CITY OF ALBUQUERQUE

Re: Solare Charter School, Phase 1
8801 Gibson Blvd SW
60-Day Temporary Certificate of Occupancy
Transportation Development Final Inspection
Engineer's/Architect's Stamp dated 6-17-19 (M09D031)
Certification dated 2-18-20

Based upon the information provided in your submittal received 2-18-20, Transportation Development has no objection to a 60-day Temporary Certificate of Occupancy based. This letter serves as a "green tag" from Transportation Development for a 60-day Temporary Certificate of Occupancy to be issued by the Building and Safety Division.

PHASE CDS

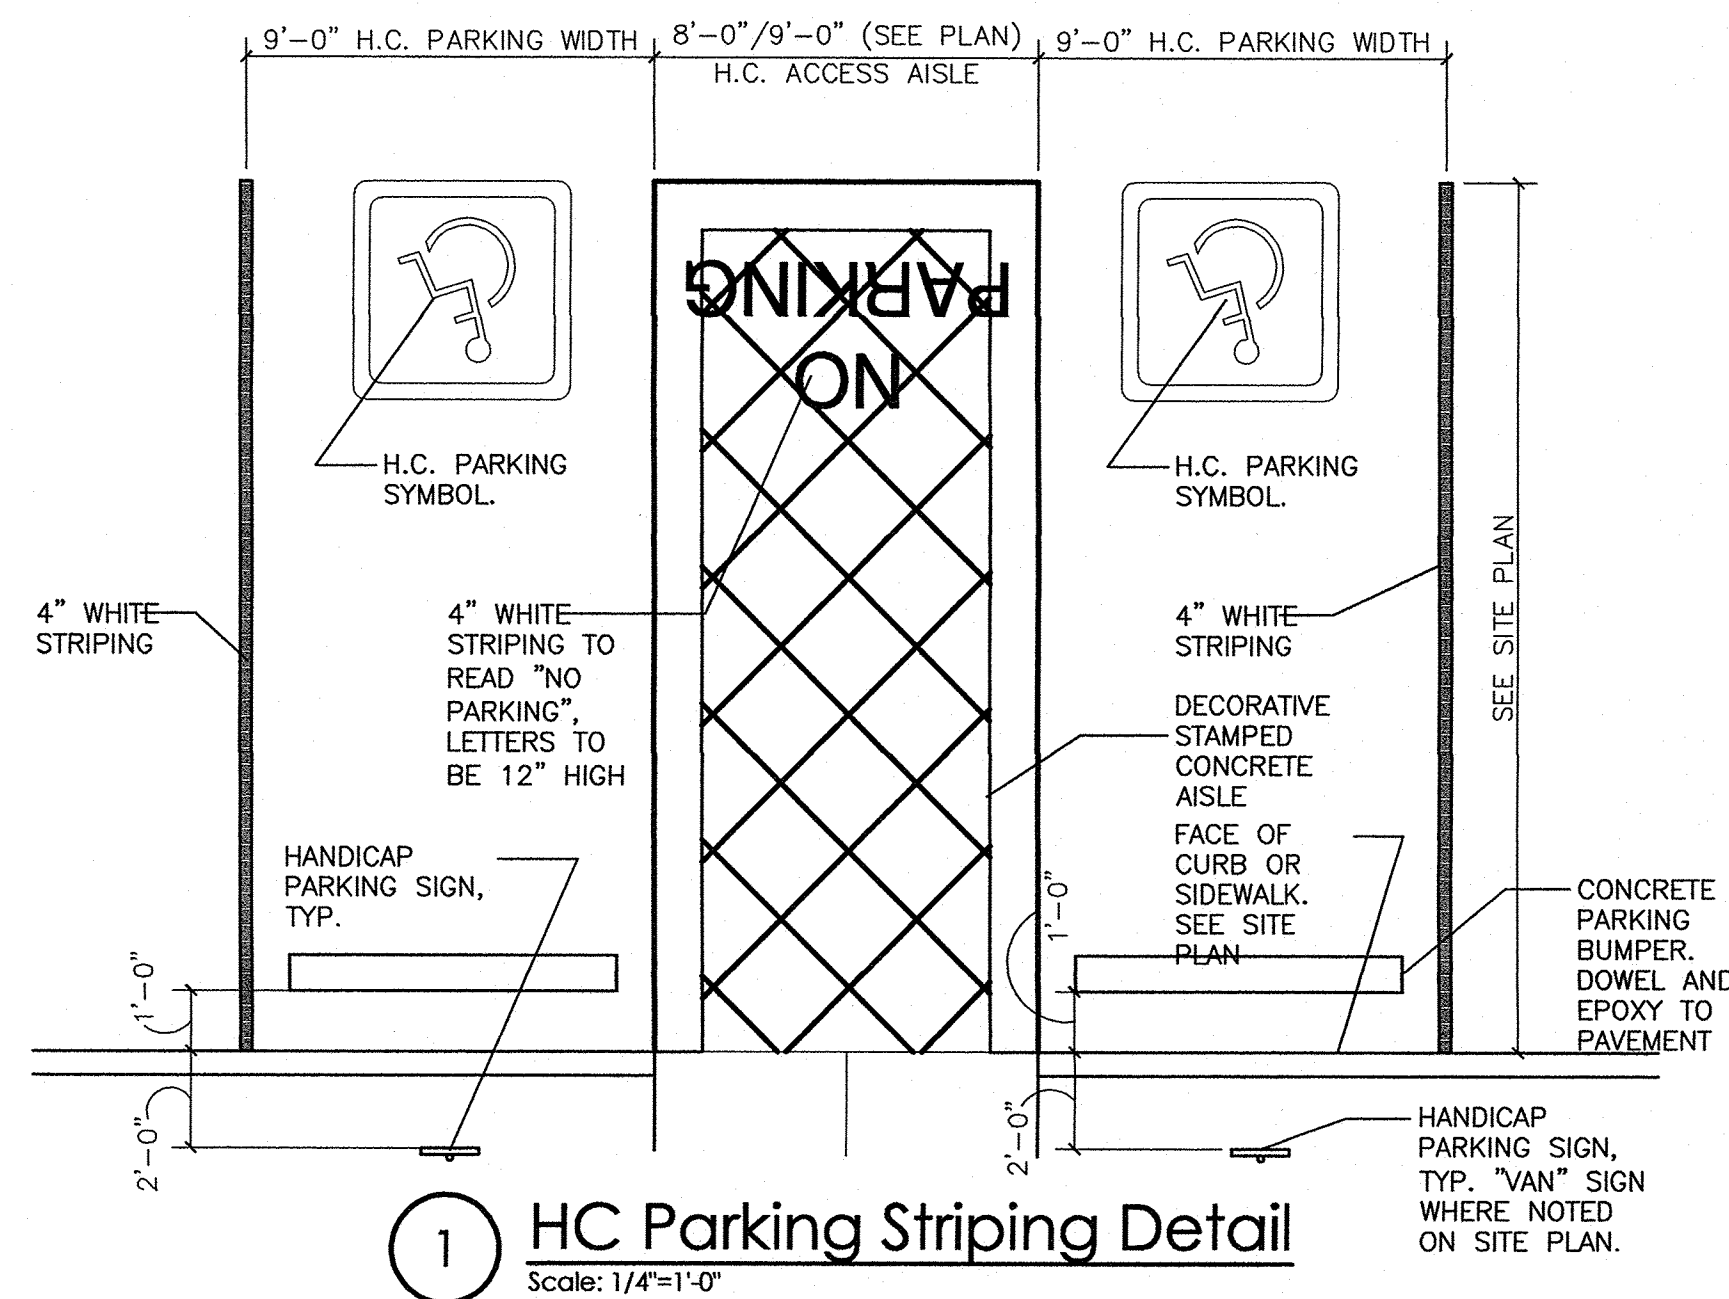
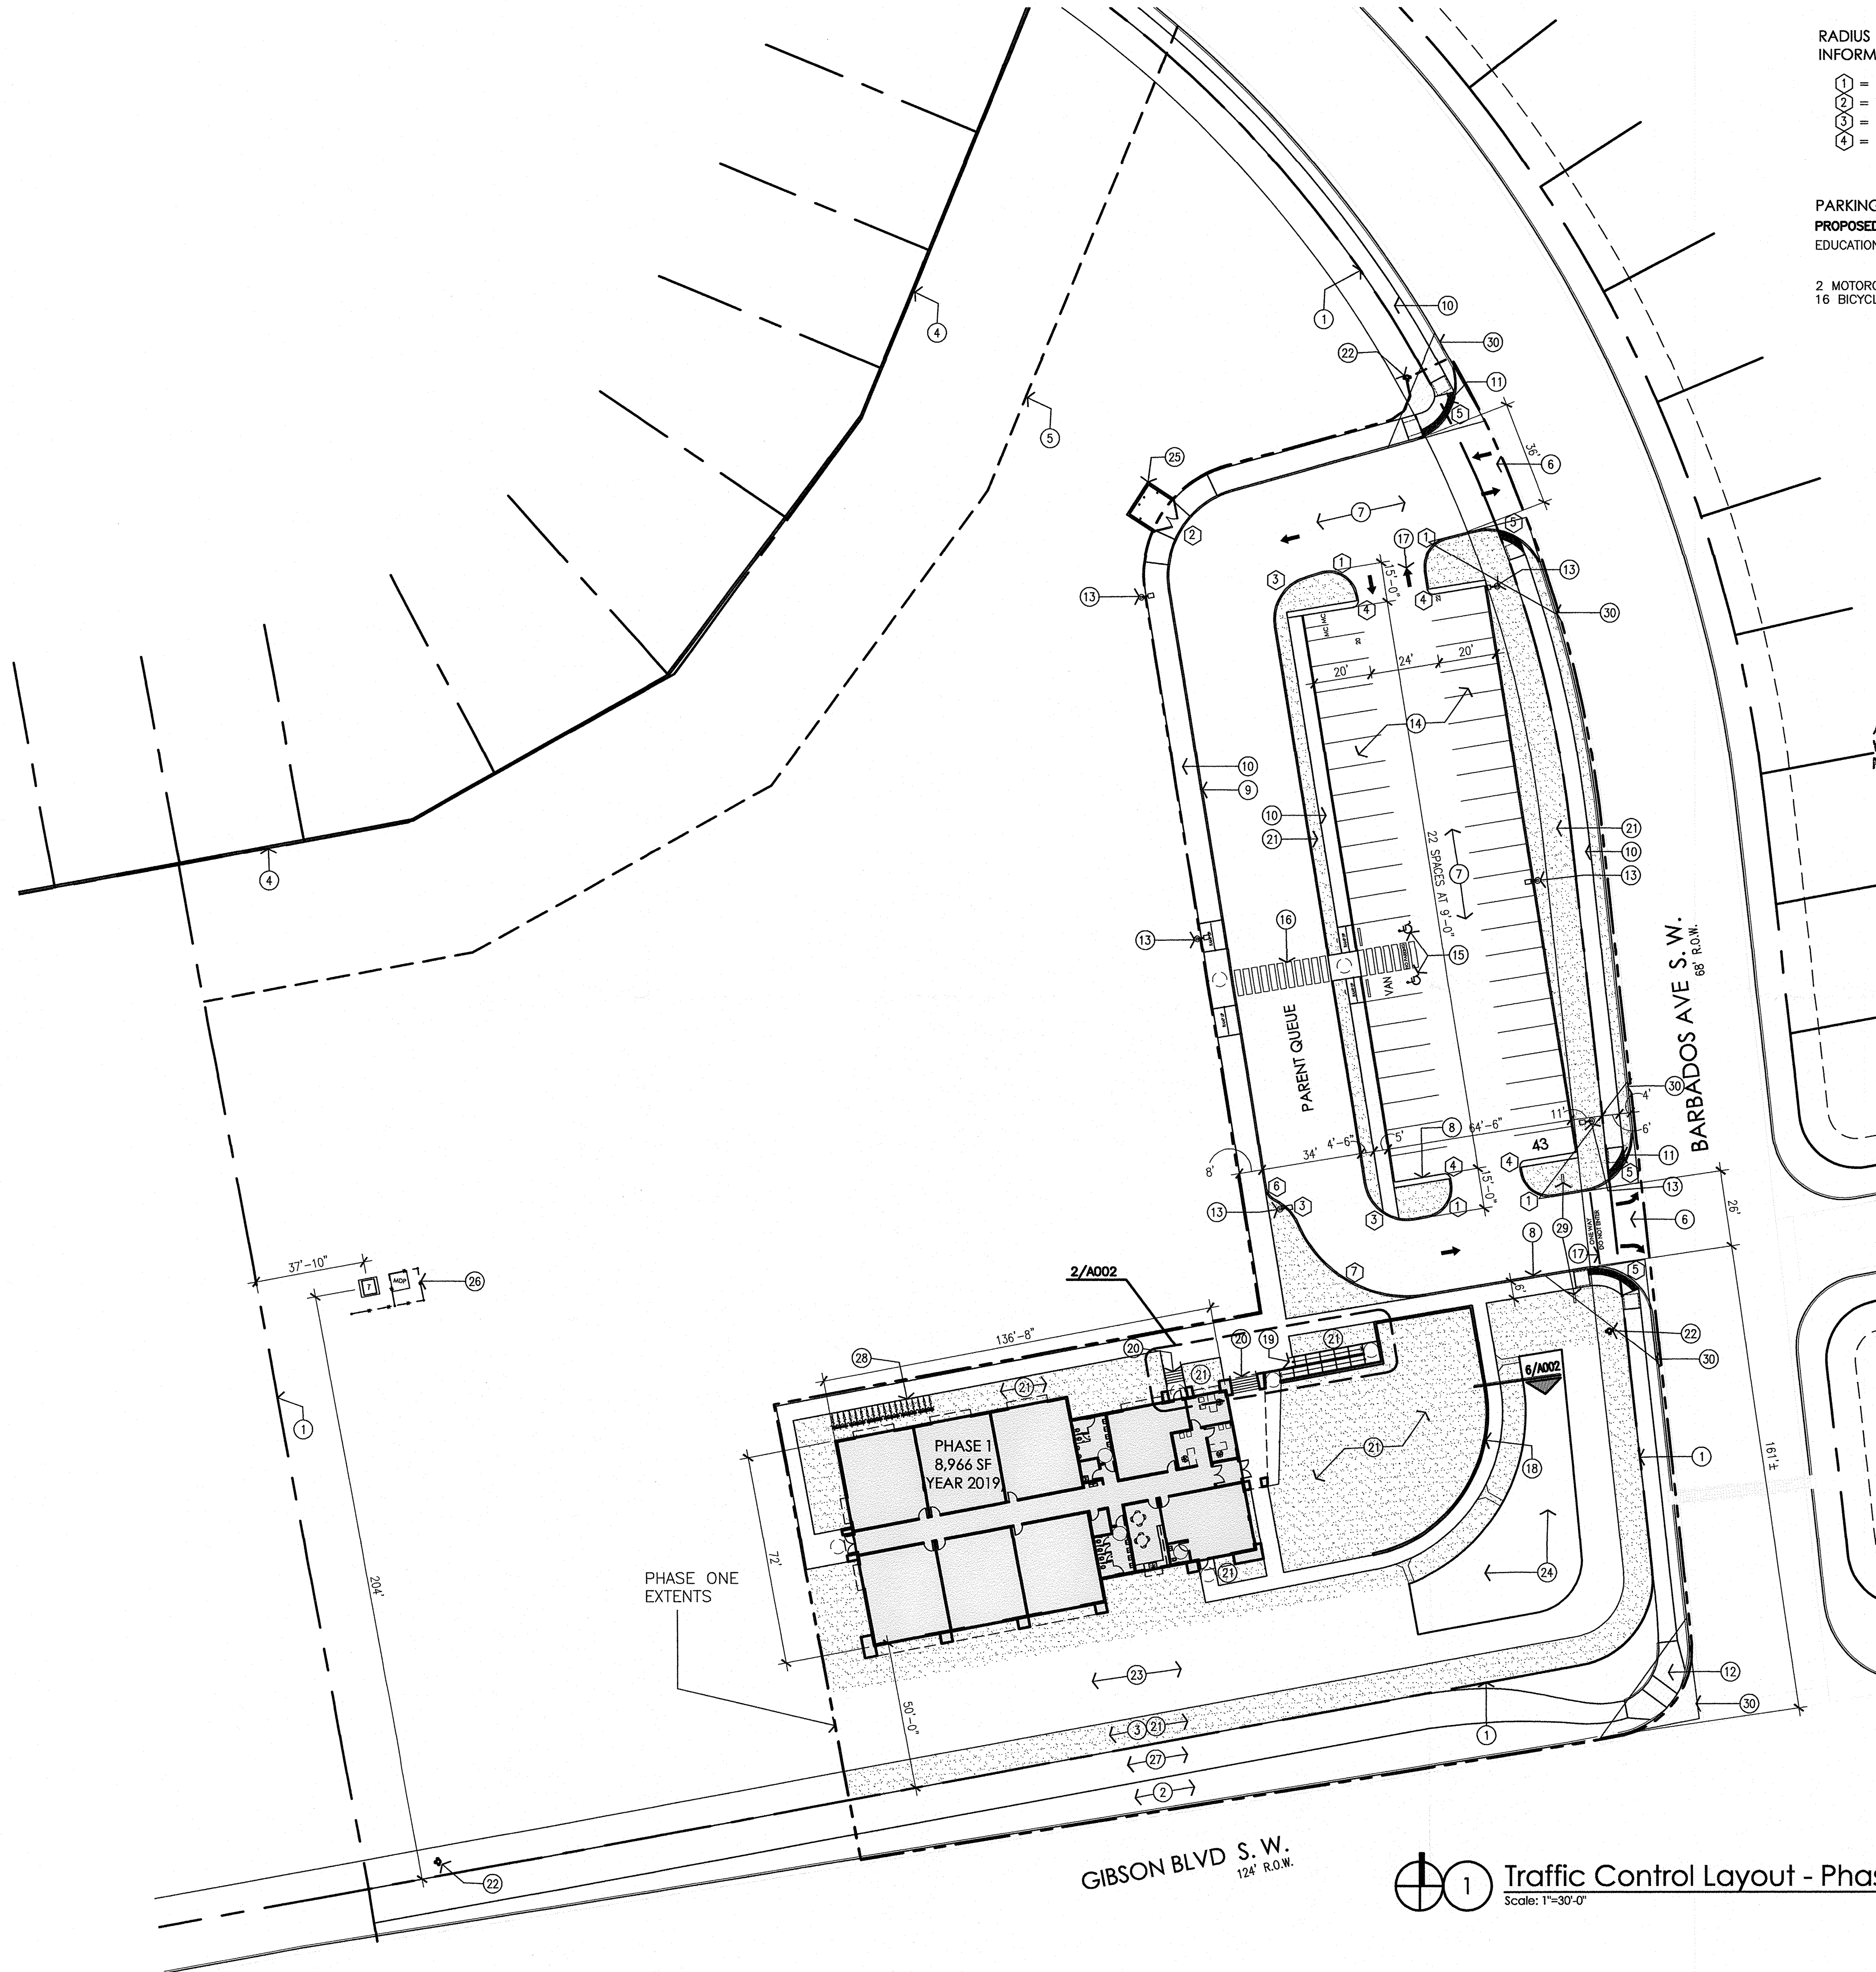
- Please complete bike trail keynote #27.
